WEST SUSSEX COUNTY COUNCIL CONSULTATION

TO:	Arun District Council - FAO: Anita Gardner
FROM:	WSSC - Highways Authority
DATE:	27 November 2020
LOCATION:	Lower Farm, Yapton Lane, Walberton, BN18 0AS
SUBJECT:	WA/62/20/PL Construction of 5 hectares of glasshouses, a service area & a reservoir on agricultural land. This site is in CIL Zone 3 (Zero Rated) as other development.
RECOMMENDATION:	No Objection

TITLE	
Proposed Site Layout Plan	
SCALE	As shown @ A3
PROJECT No.	23375
REPORT TYPE	Transport Statement
DRG. No.	04

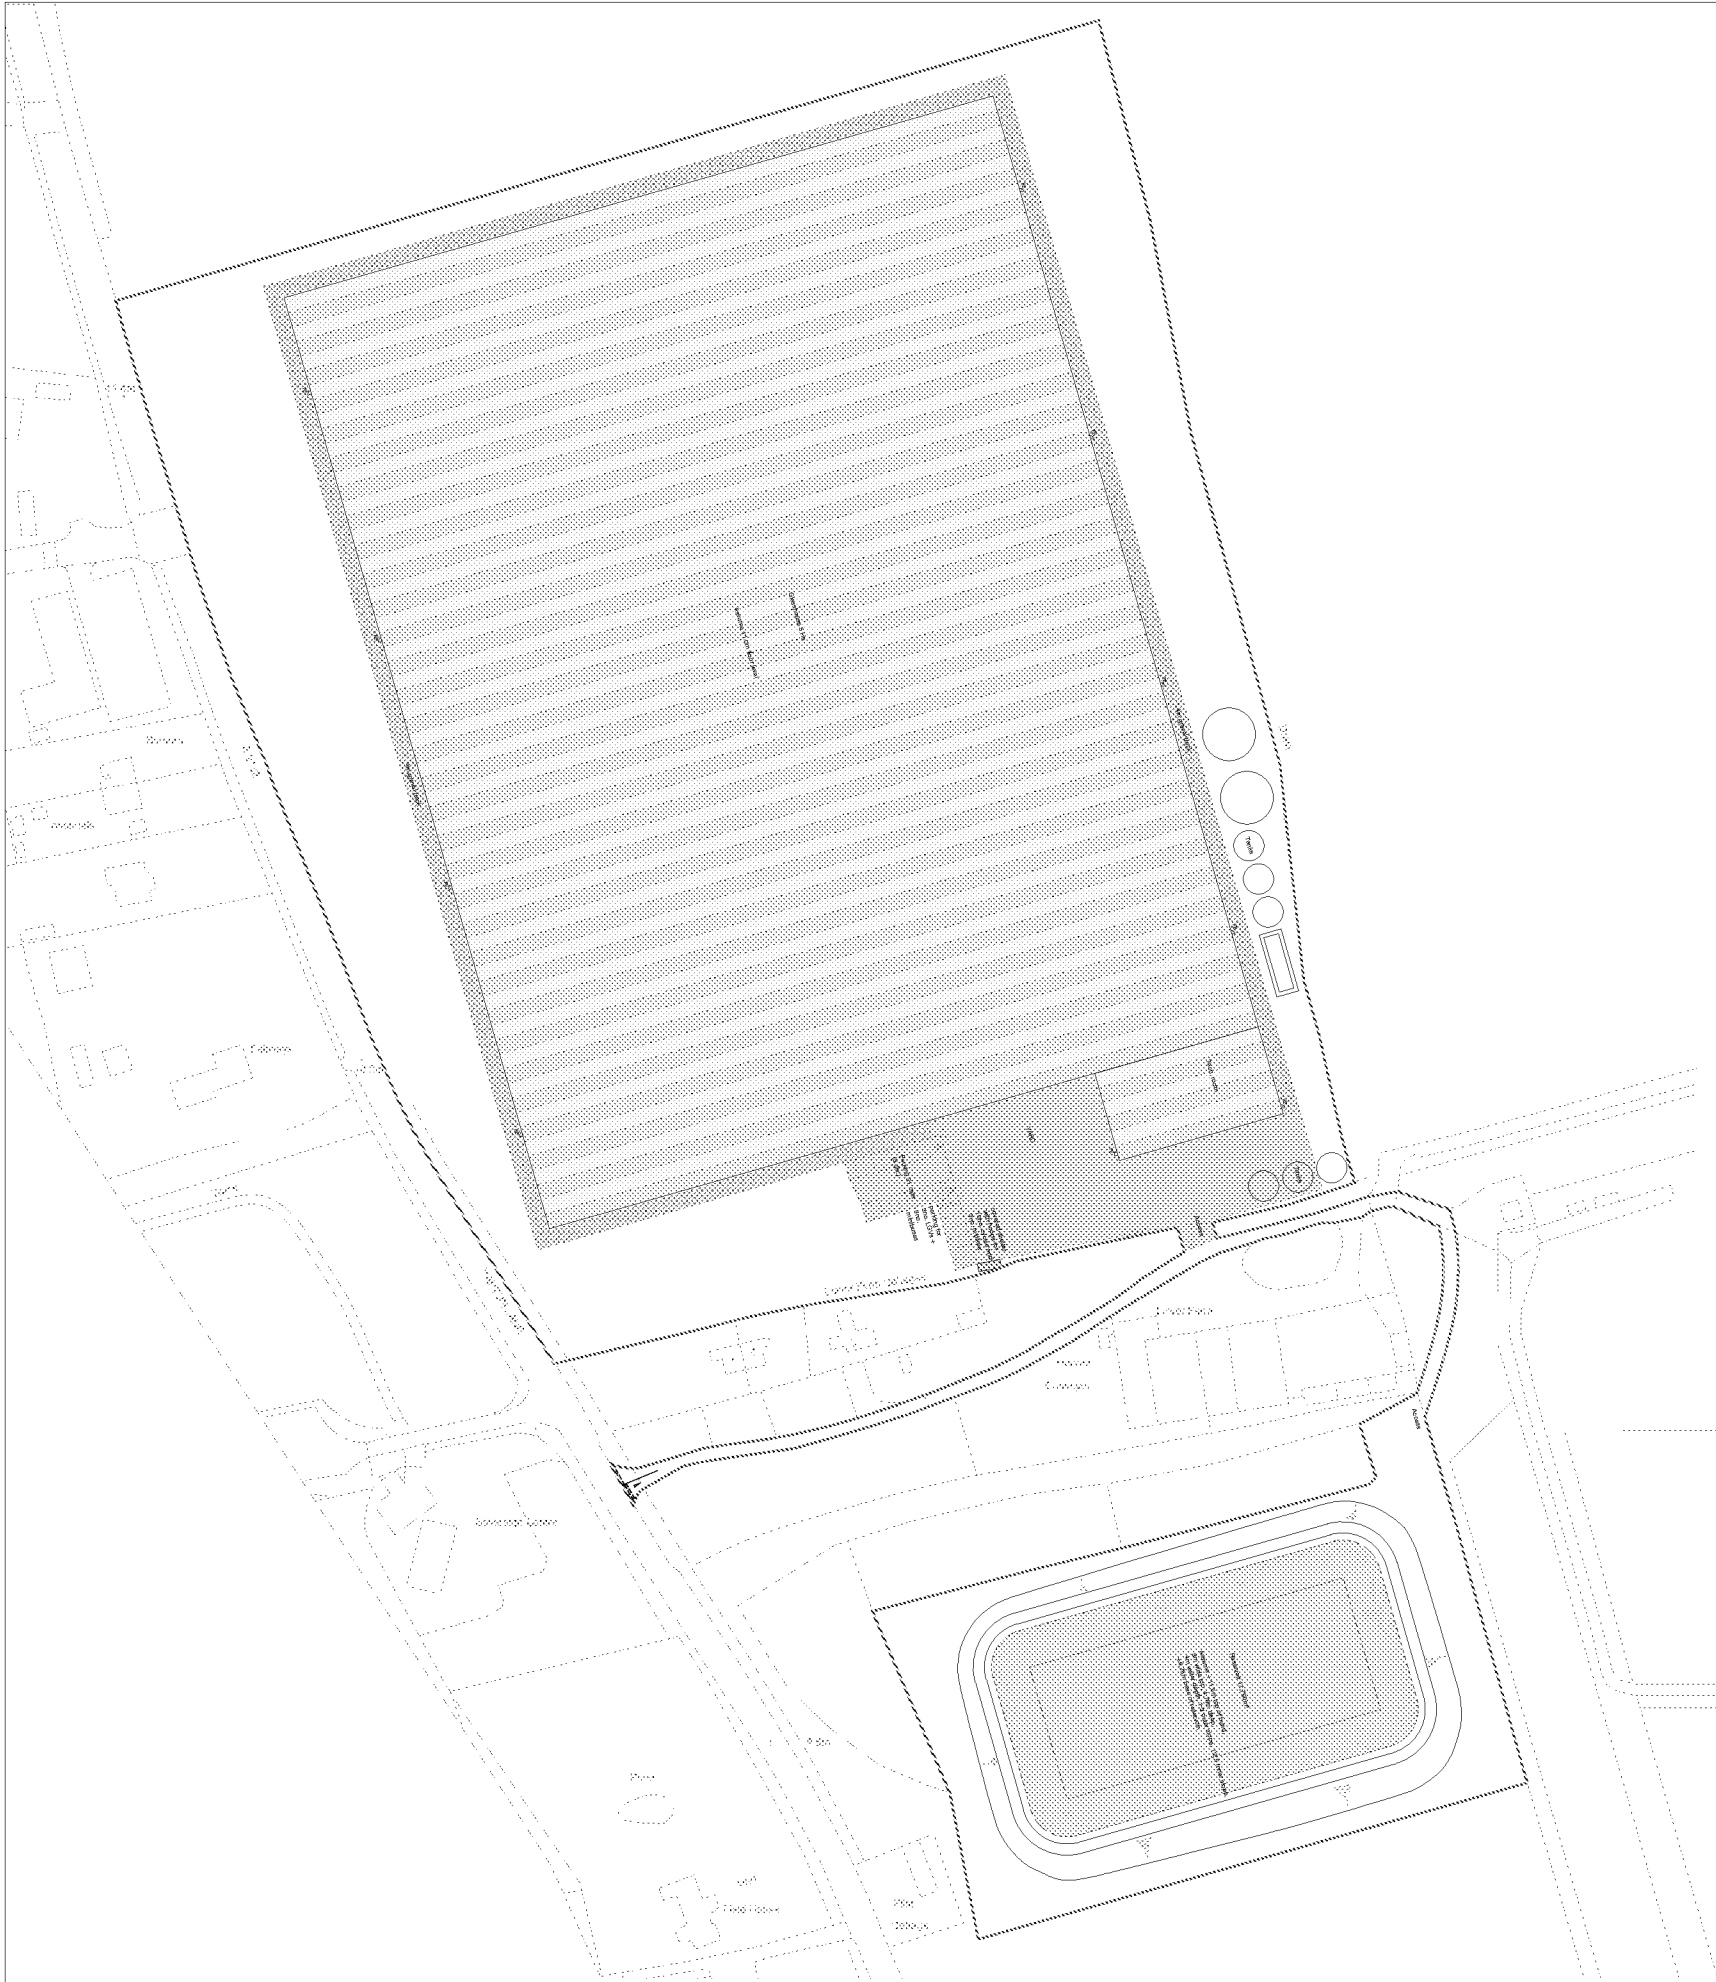
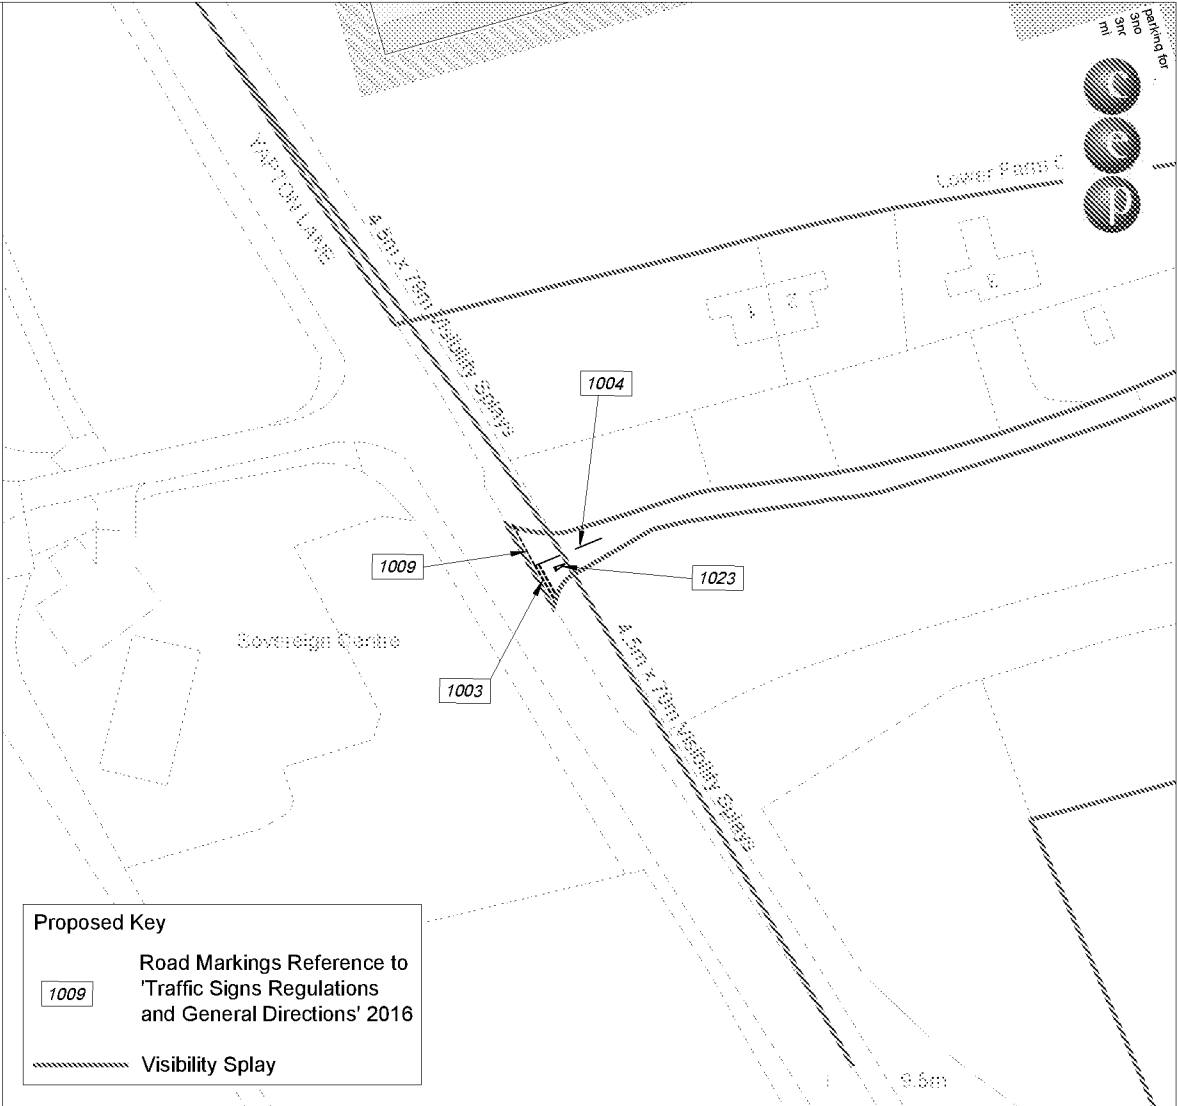
Based on the site specific needs of the use a total of 27 x vehicle parking spaces are proposed which includes 3 x disabled bays and 6 x LGV / minibus bays. The TS also refers to a motorcycle and bicycle parking facility. It is evident from the site block plan that there is sufficient space for parking for all modes and HGV access and turning within the 'yard' area.

No part of the development shall be first occupied until the car parking has been constructed in accordance with the approved site plan. These spaces shall thereafter be retained at all times for their designated purpose.

Proposed Site Layout Plan and Swept Path Analysis

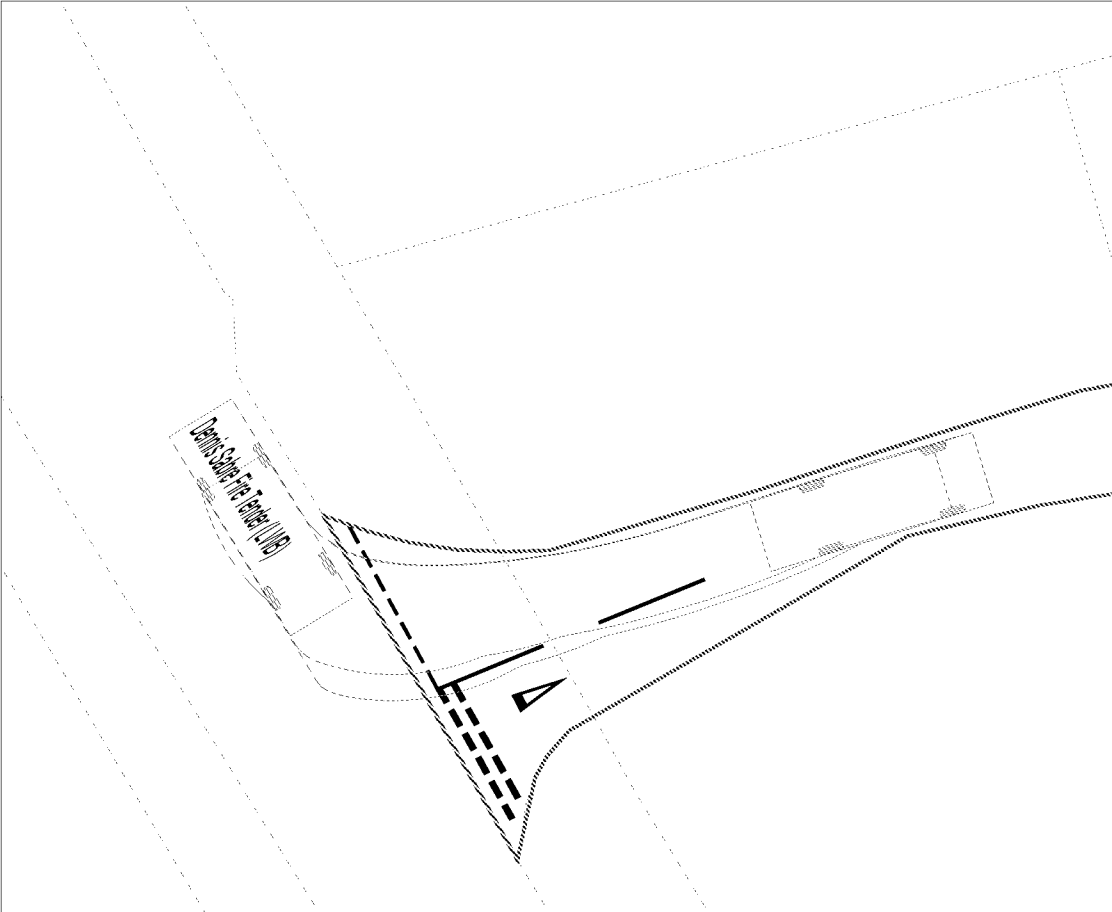
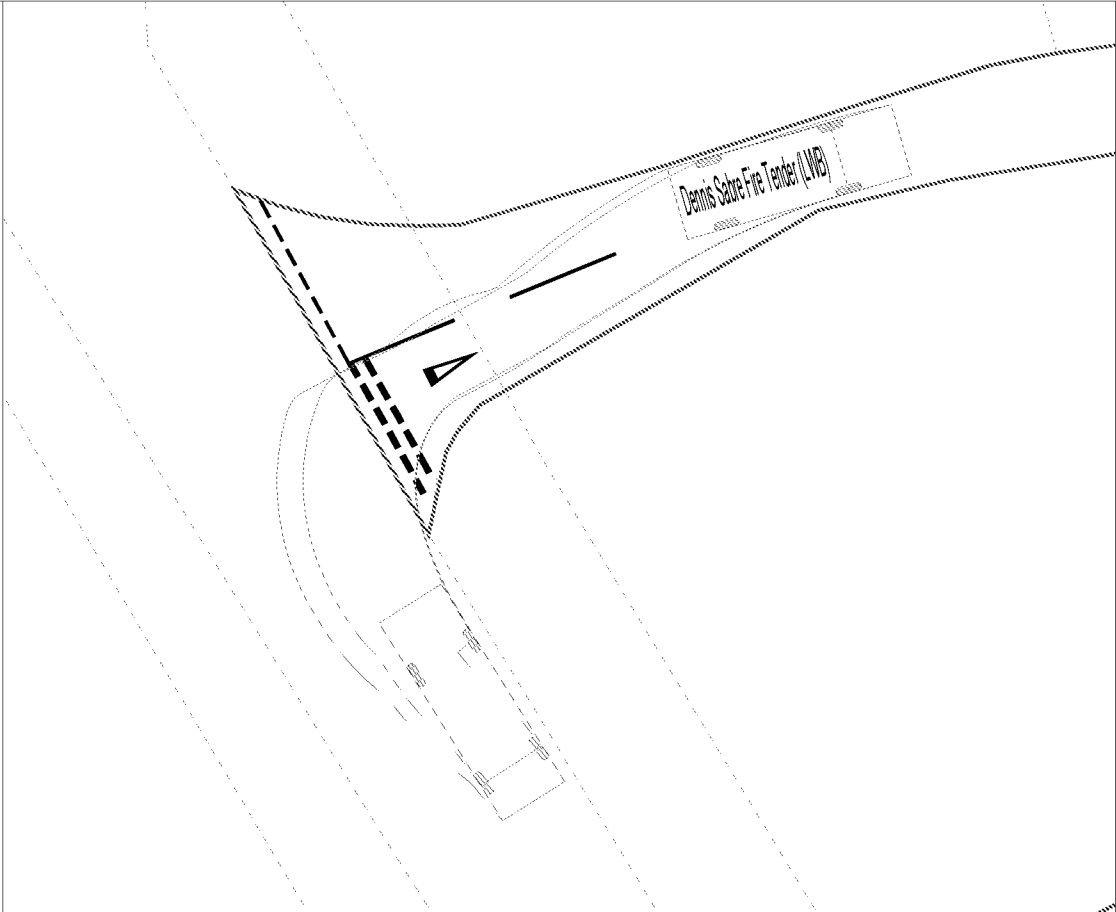
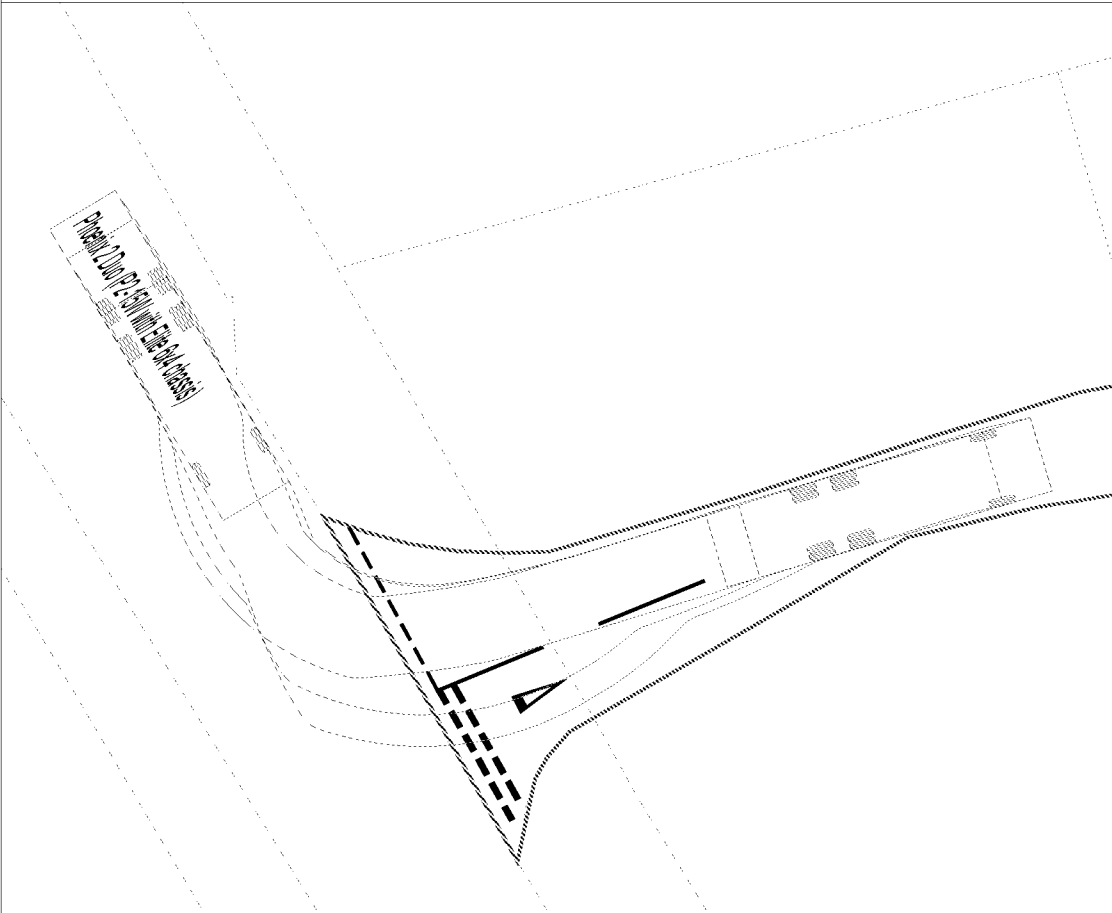
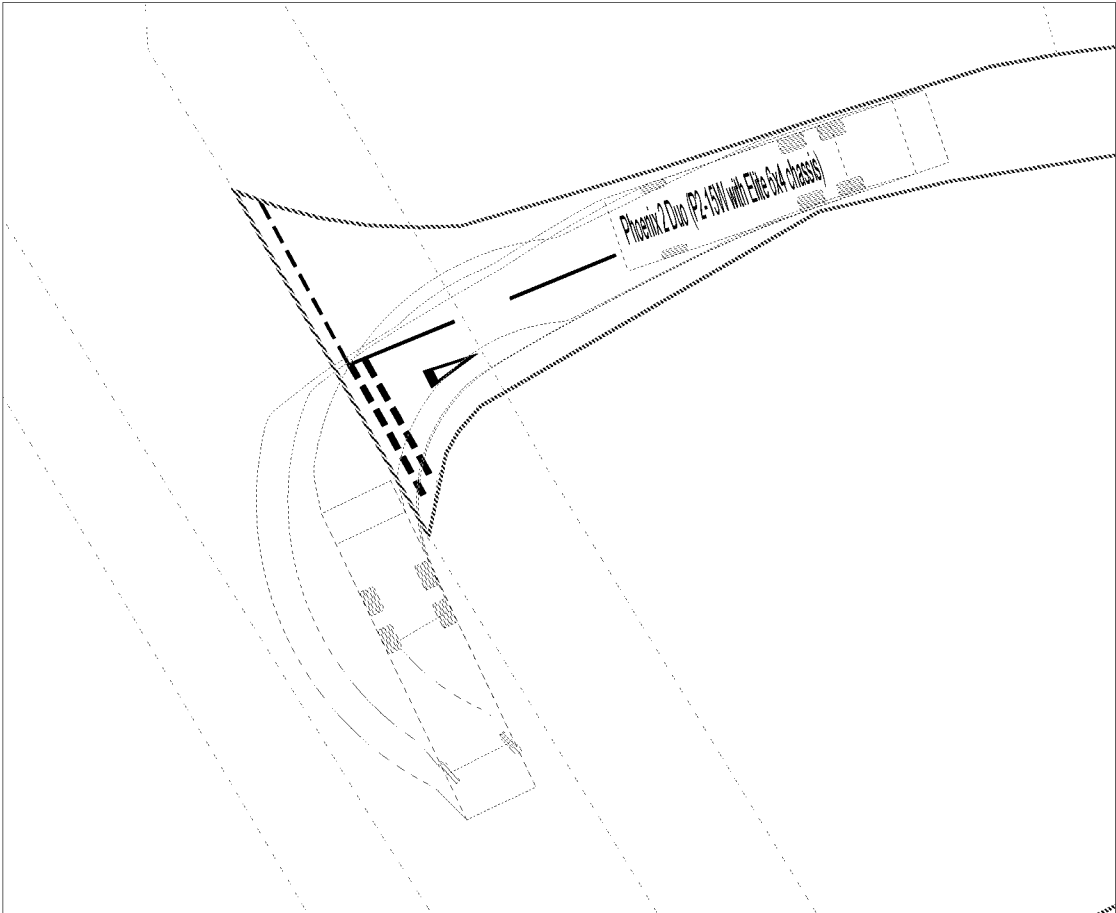
The access width and geometry appear suitable for the proposed use. Give way markings and white lining are proposed - the applicant would be required to contact Area Office to arrange for this. Swept path tracking plans have been provided showing that a fire tender and refuse collection vehicle can manoeuvre the existing access point.
